**Consultation Response from: KC Environmental Health (Pollution & Noise Control)**
**2023/90668 - Grange Moor Coachworks, Barnsley Road, Grange Moor, Huddersfield, WF4 4DR**

**Erection and operation of a single building comprising a Sui Generis land use limited to the purpose of storage, assembly, sale and distribution of custom-built computers, laptops and their components as well as any associated development (those being a replacement wind turbine, utility provision, drainage, access, hard and soft landscaping) within the red-line boundary alongside business operations pursuant to the effective administration of the Sui Generis use.**

**Responding Date:**  
**05 October 2023**
**Responding Officer:**  
**Mohammed Nasim**
**Responding Ref:**  
**WK202329880**
**Comments**
**Noise**

Description  
PROPOSED BOUNDARY TREATMENT PLAN

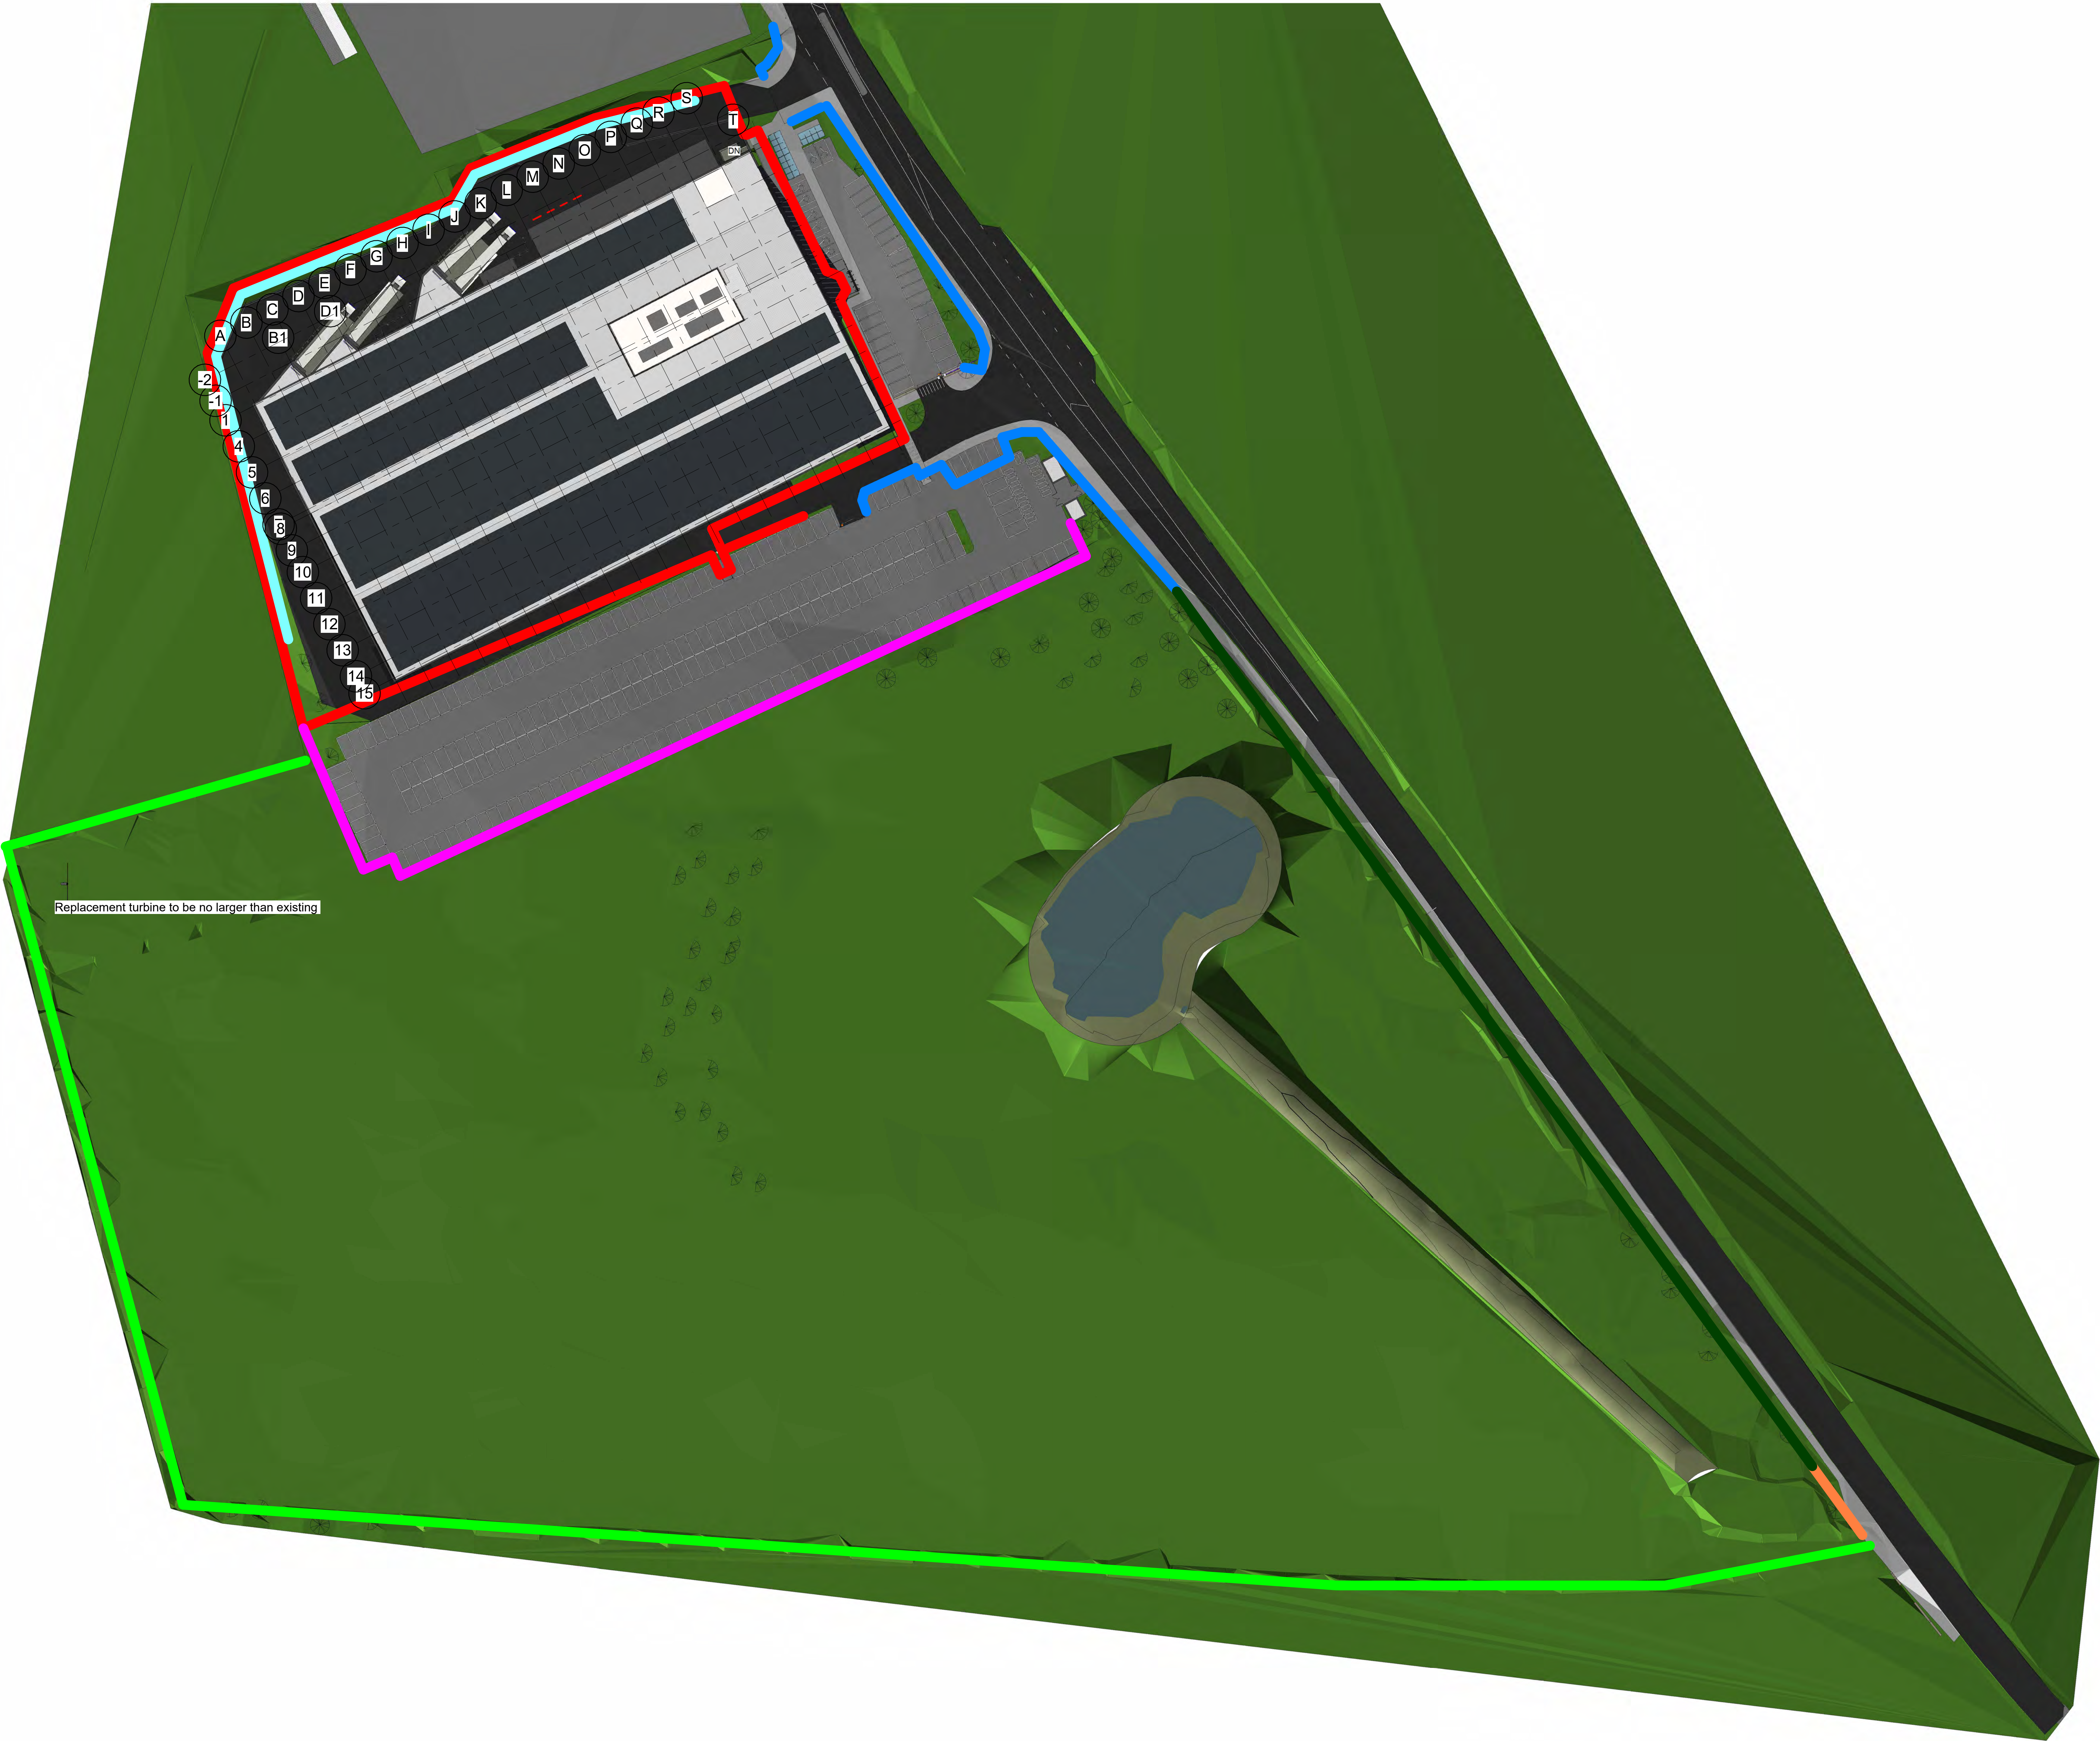
As the applicant premises will be expanding, we expected an increase in staff and business vehicles and the submitted NIA considers this in section 6. Reasoning is given on the number and timings of deliveries and there is a proposal to increase the 2m garden fencing to 3m along the boundary to provide some attenuation and also to block line of sight from the properties to the delivery area. Based upon typical levels of HGVs and a total of 40 HGV movements (2 movements per delivery vehicle), calculations indicate a low impact. The NIA suggests the submission of a Noise Management Plan including avoiding narrow-band reversing alarms in favour of broadband alarms, switching off engines when stationary, staggering of delivery times and maintaining a good quality driving surface on site and this is welcomed. The staff parking area will be screened from the nearest receptors by the proposed buildings and noise from individual staff vehicle movements is therefore not expected to be significant at any of the receptors and this is accepted.

Before the development is brought into use, details of an acoustic barrier (as recommended in the Noise Impact Assessment authored by SRL dated 10 July 2023 Ref 81009-SRL-RP-YA-01-P2) shall be submitted to and approved in writing by the Local Planning Authority. The details shall include:

- A plan showing the location of the barrier
- The minimum height of the barrier relative to the adjacent ground level
- The construction specification of the barrier including the barrier support structure, the barrier material, the minimum barrier thickness, the minimum density of the barrier material and the details where the barrier meets the ground.
